JUDGE ORR RANCHETTES

CONSTRUCTION DOCUMENTS

PCD FILE NO:
SP-17-021

REV.	DESCRIPTION	DATE
1	ADDRESS AGENCY COMMENTS	10/23/18

JUDGE ORR RANCHETTES
SIGNAGE & STRIPING PLAN

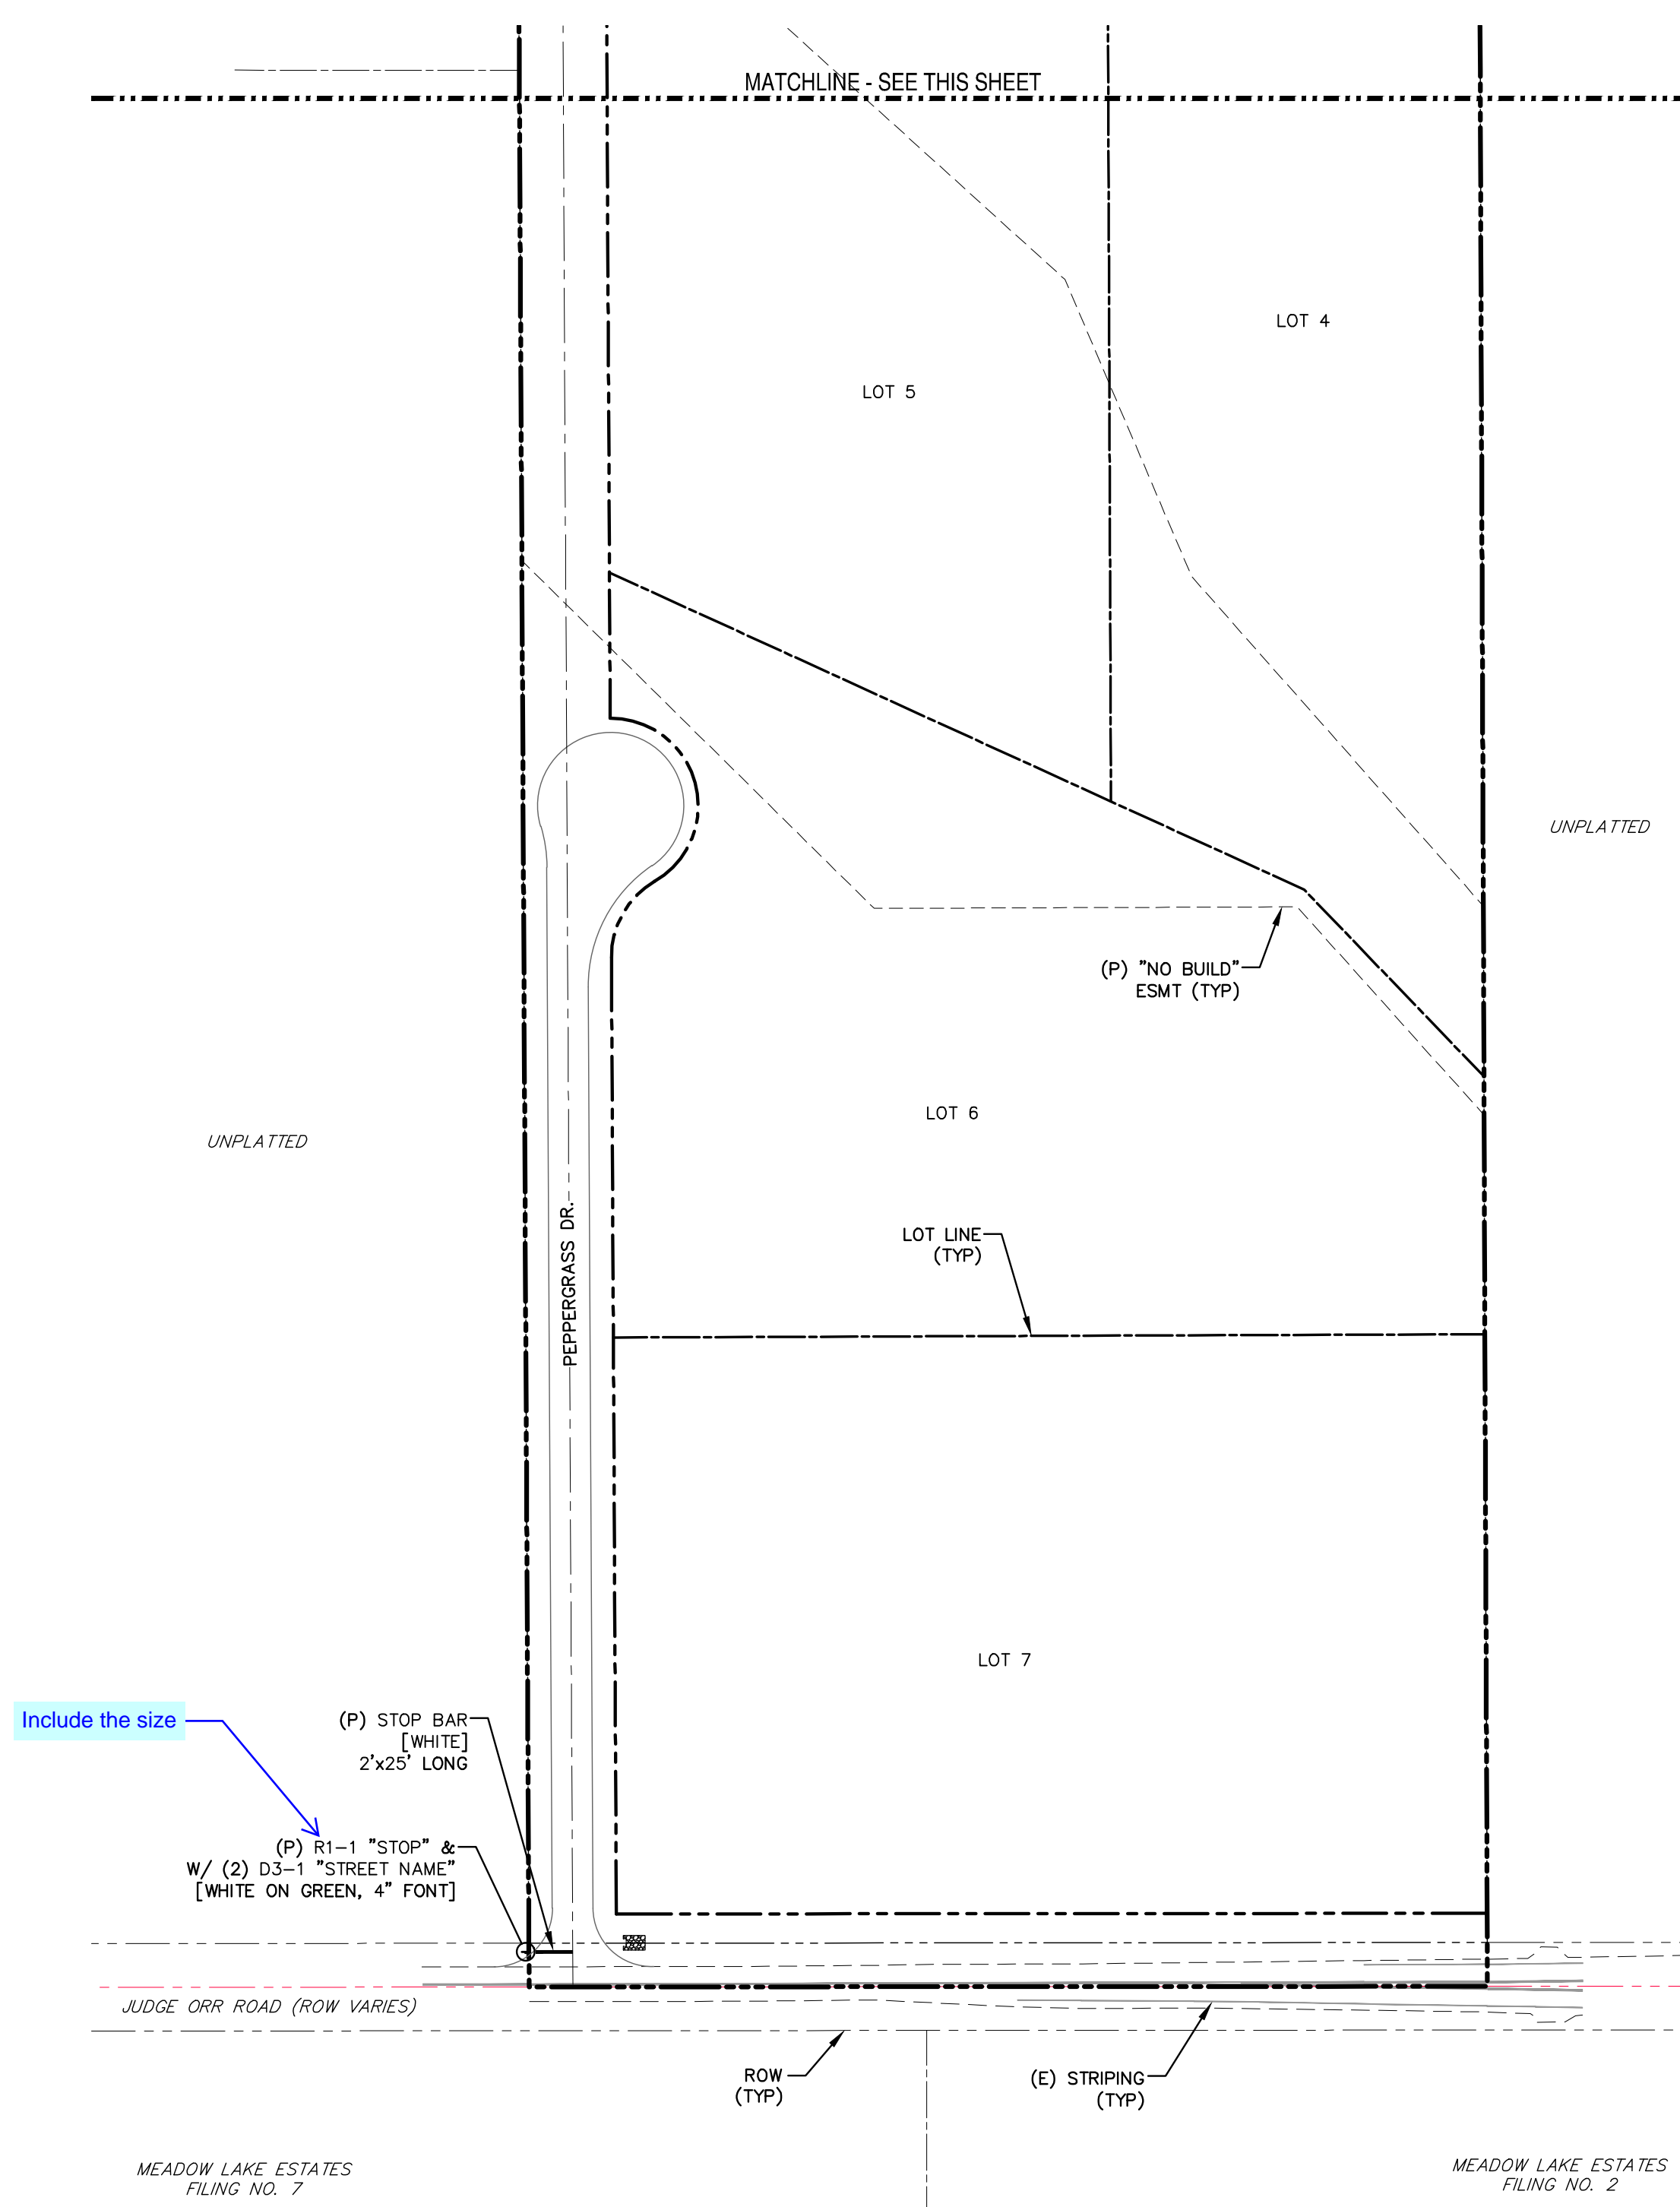
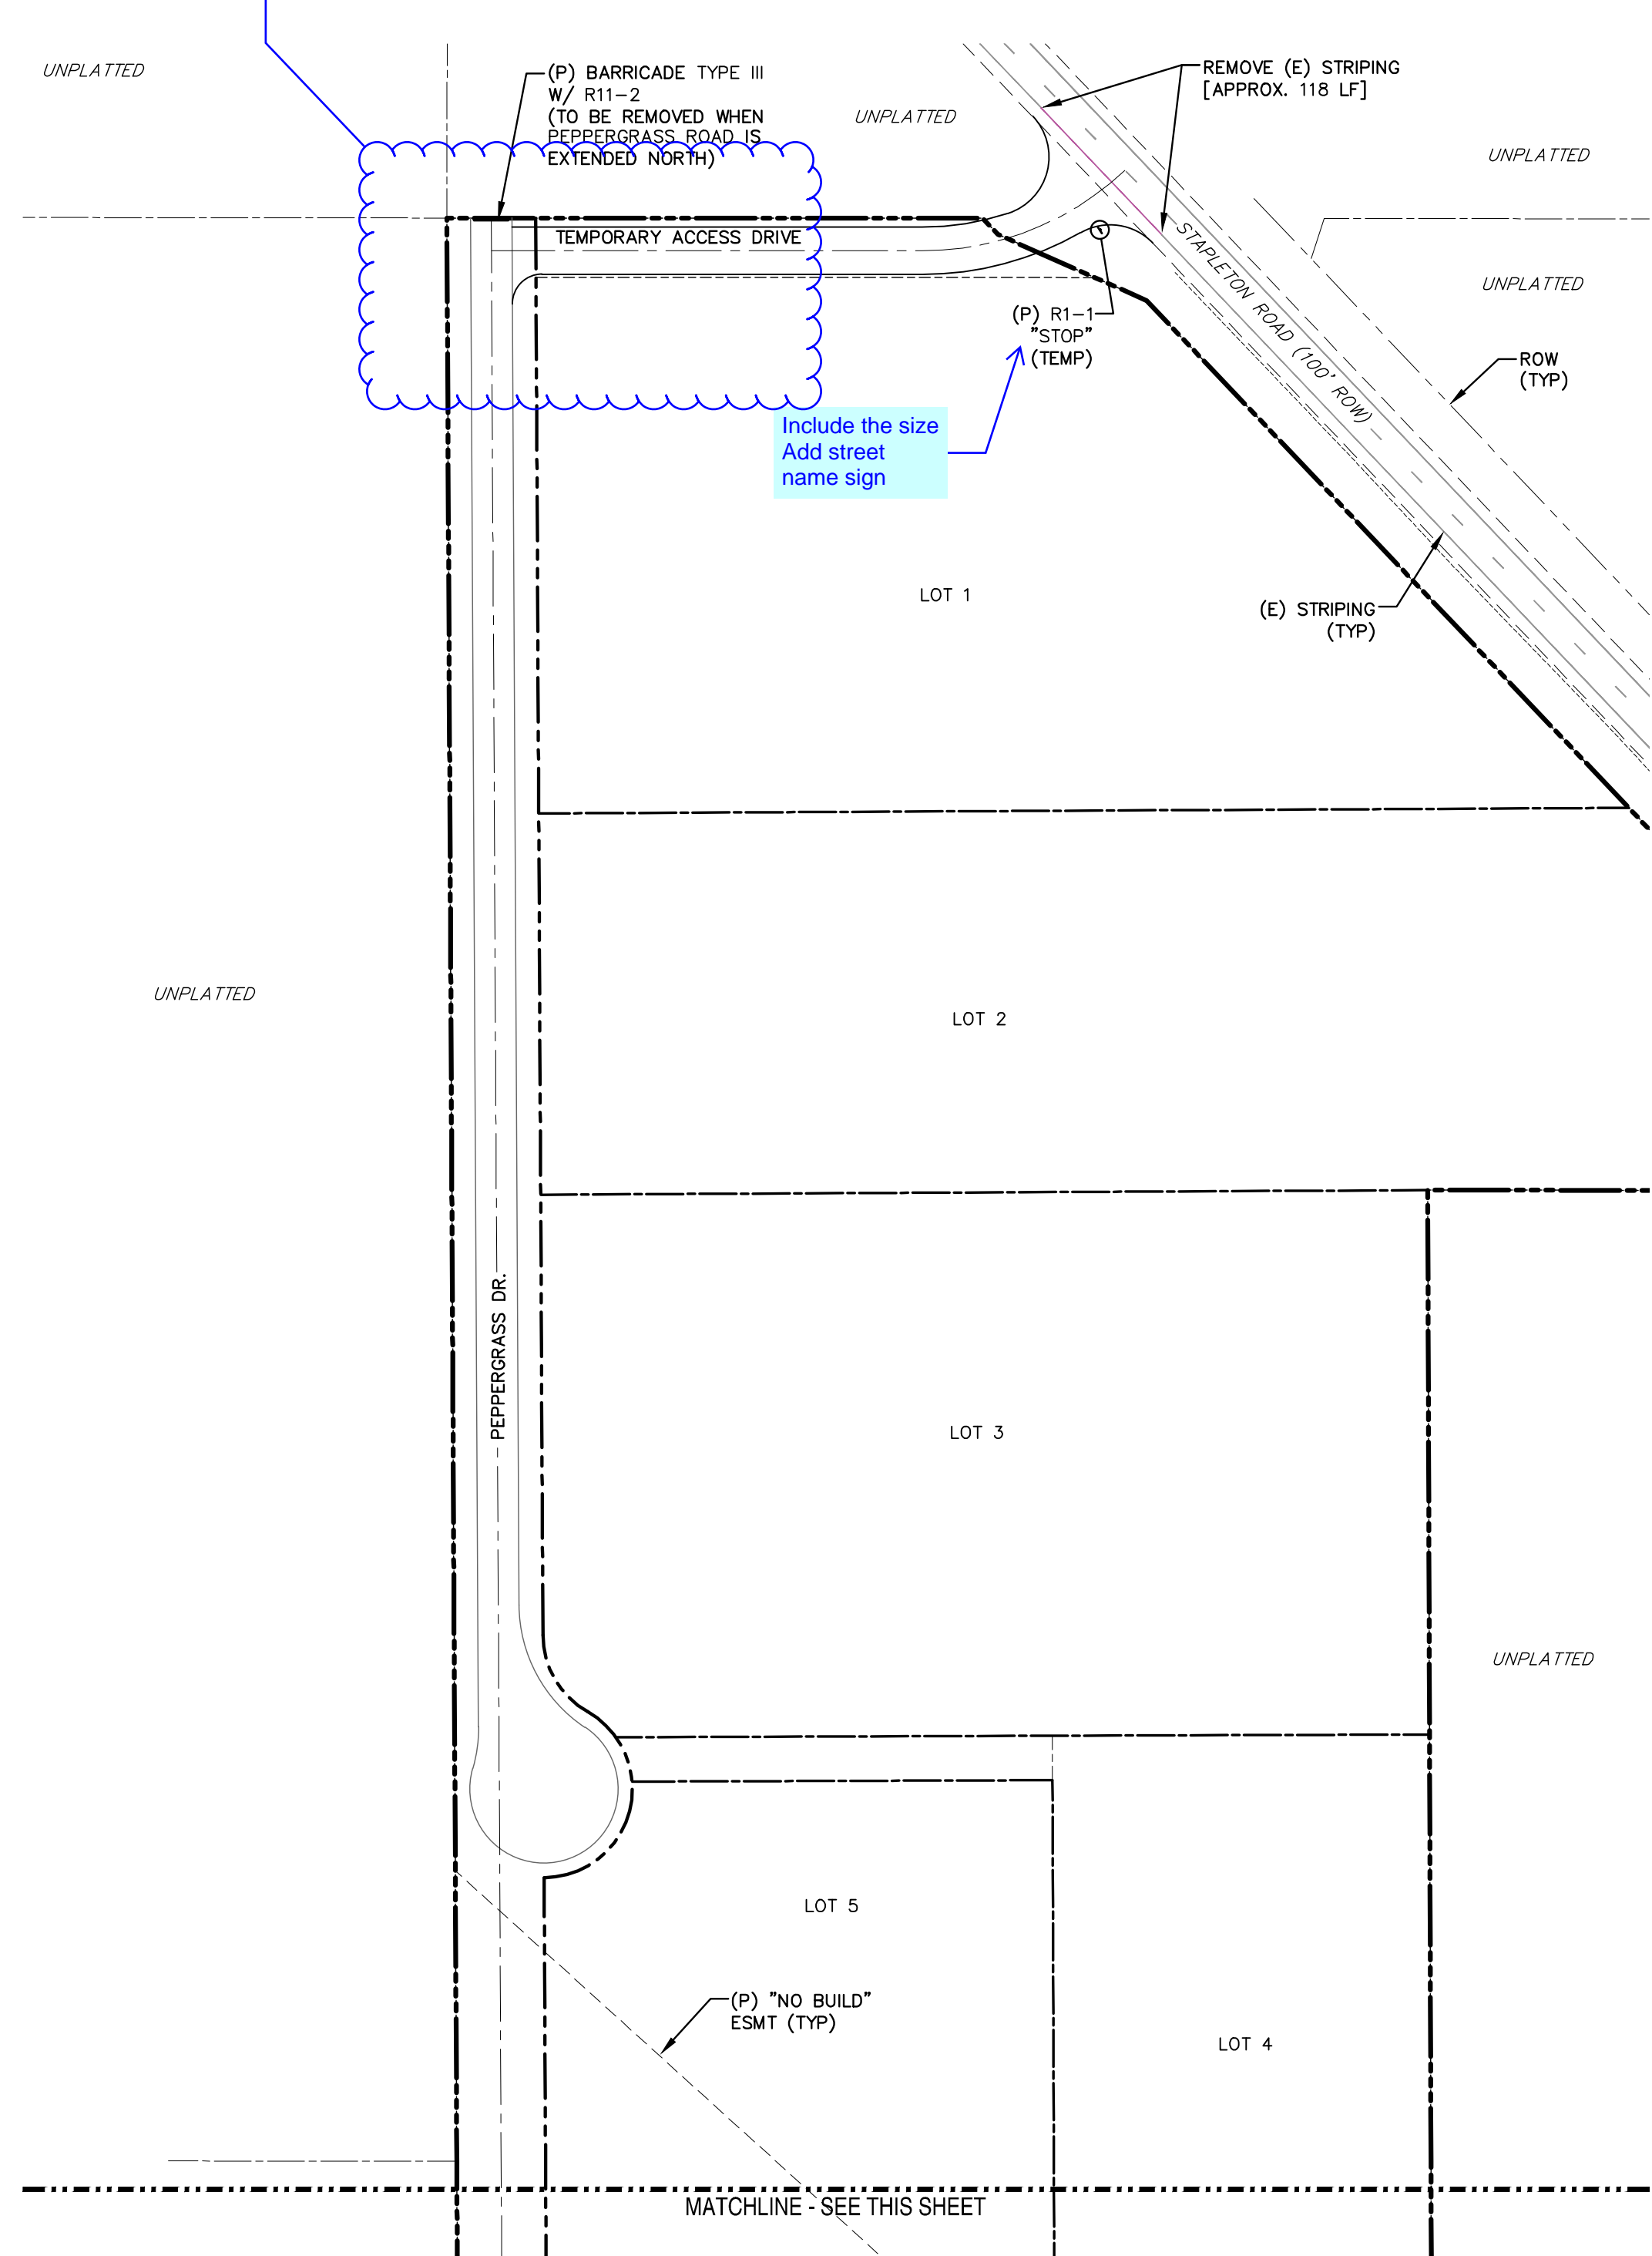
Update Sign designation to W13-1P.
Revise size to 18"x18" per MUTCD for single lane conventional road.
